From: Anita Gardner <Anita.Gardner@arun.gov.uk>
Sent: 08 December 2020 08:48
To: Planning.Responses <Planning.Responses@arun.gov.uk>
Subject: FW: Objection to Planning Application - AB/114/20/PD

Objection to Planning Application
AB/114/20/PD
Riverside House
2 Fitzalan Road
Arundel

BN18 9JS

Drawing Title:
PROPOSED PLANS

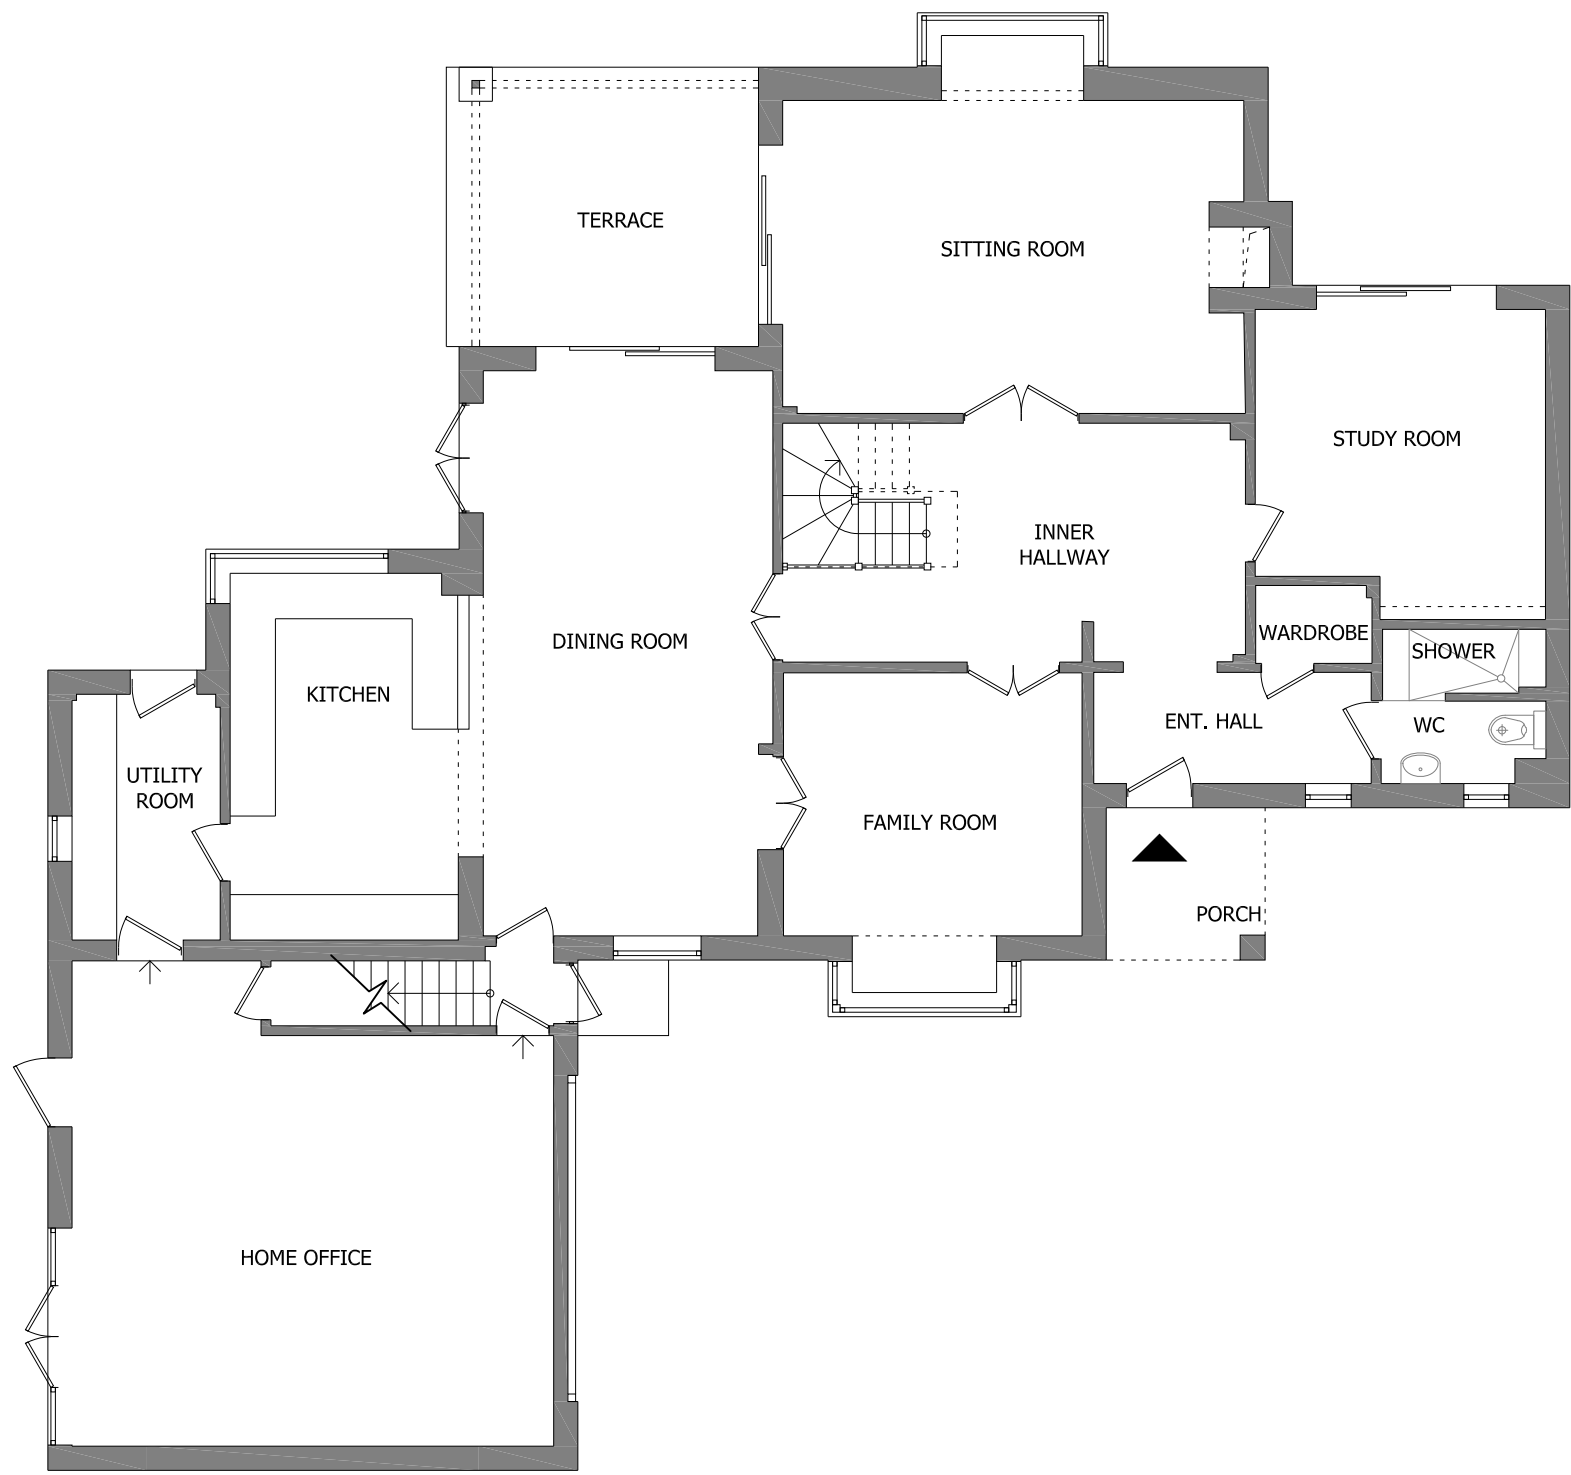
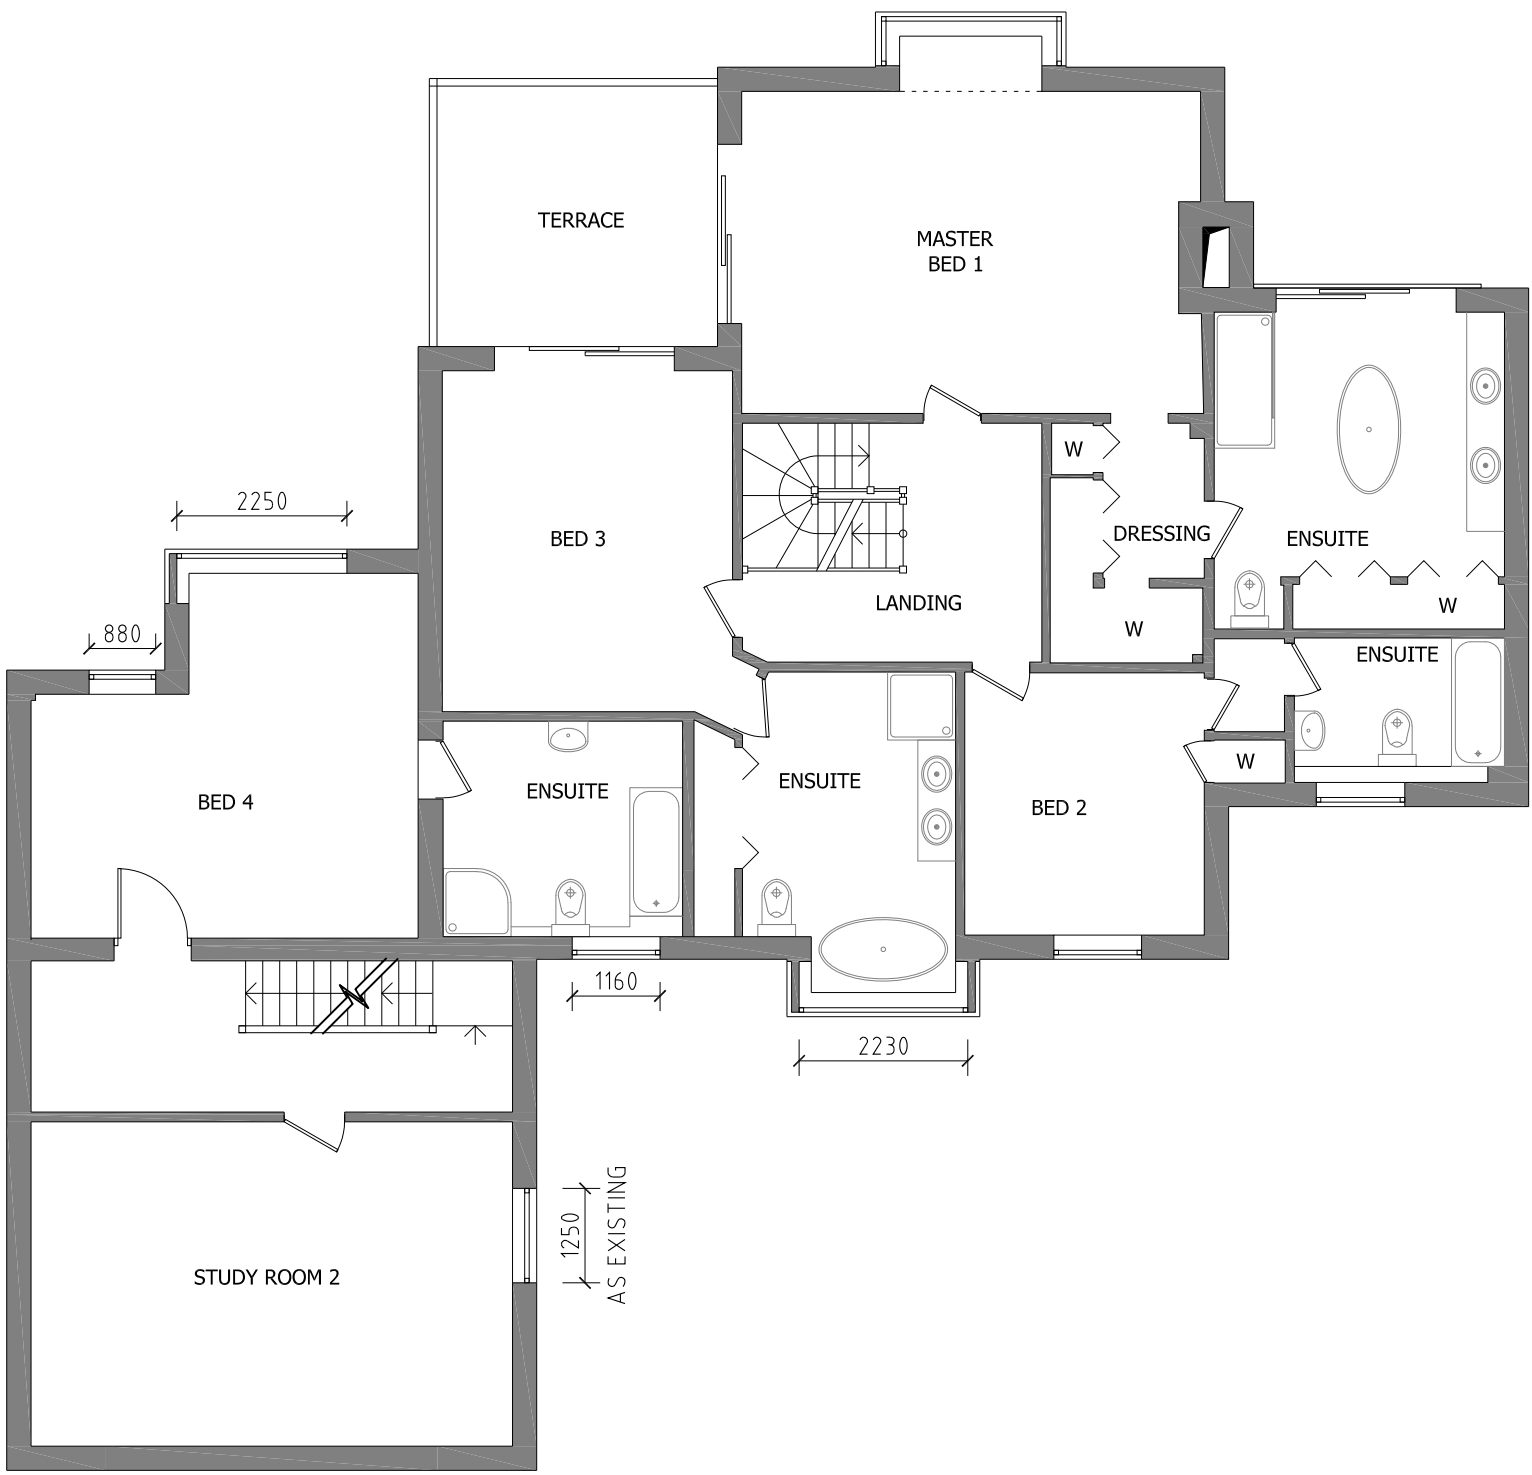
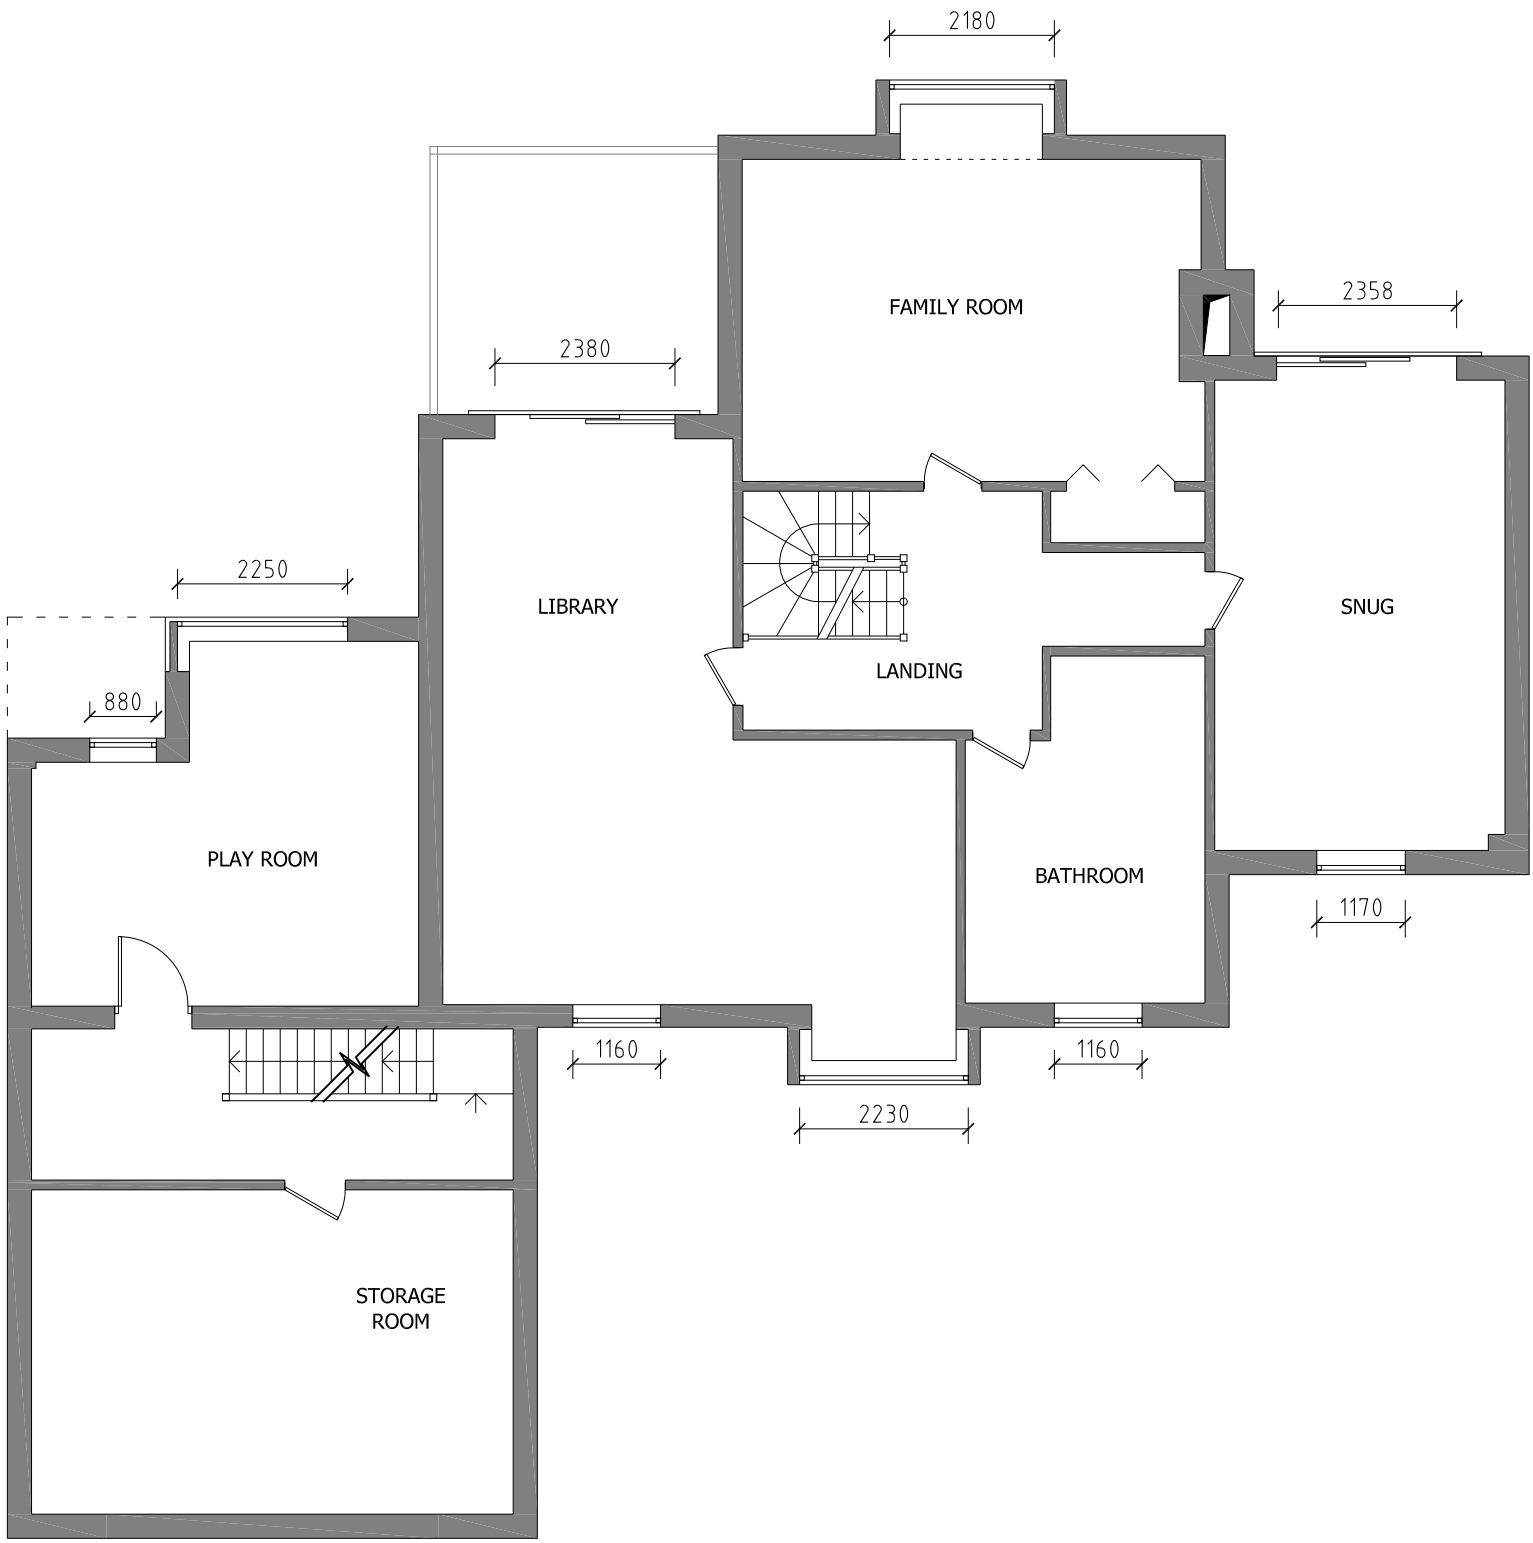
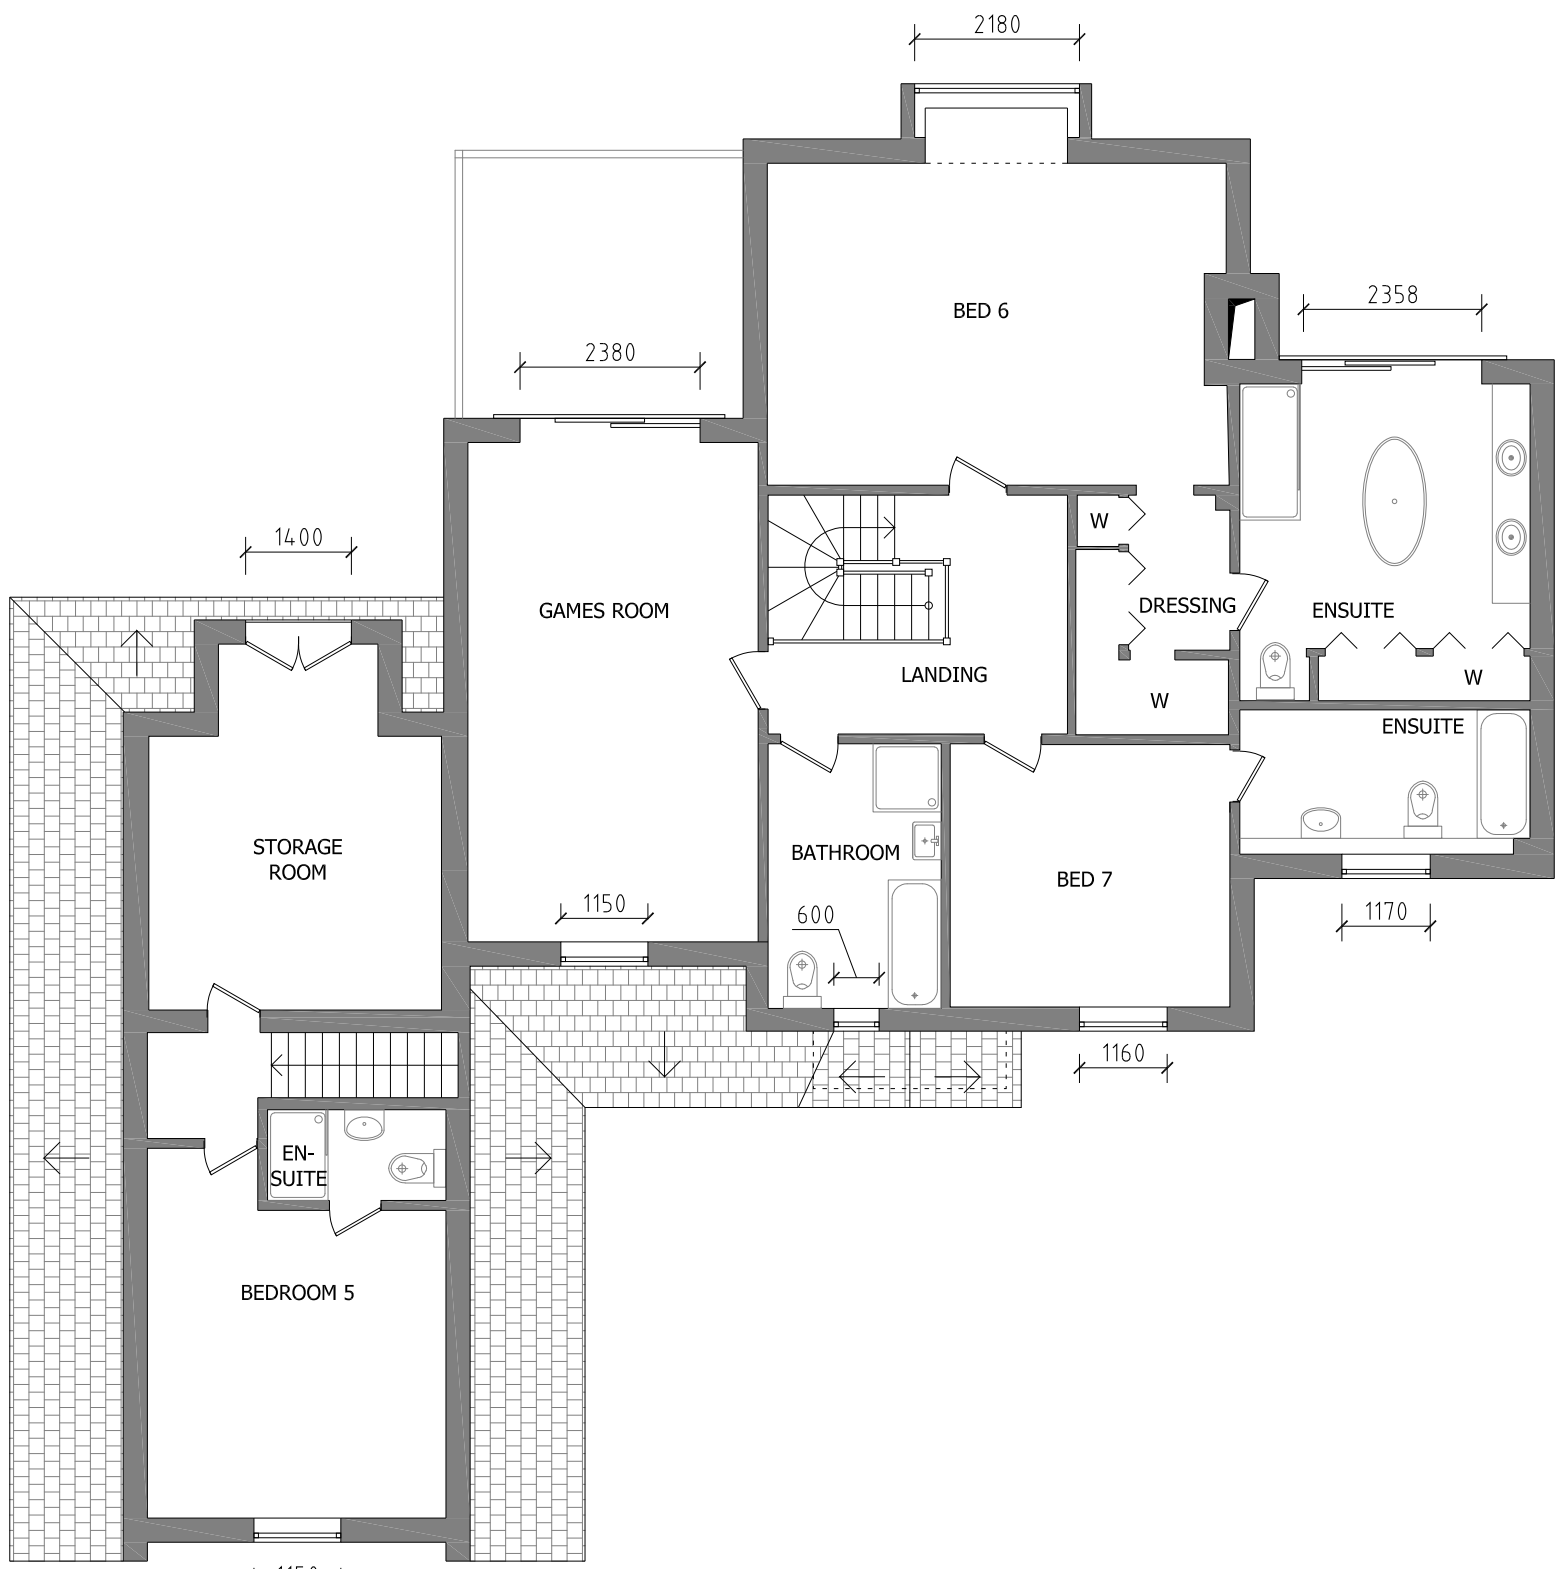
3. The proposed elevation will obscure the view into and out of the Arundel Conservation Area, much to its detriment.
4. I note from the plans that there are some eleven proposed bathrooms, the future intent for which is surely a multi-occupancy dwelling of several flats. If this is indeed the case it should be declared as such, and not become an example of incremental development by stealth. If the intent is for a multi-occupancy building then parking requirements should be appropriately scaled, and the increase in traffic taken into consideration at this stage of the planning application.
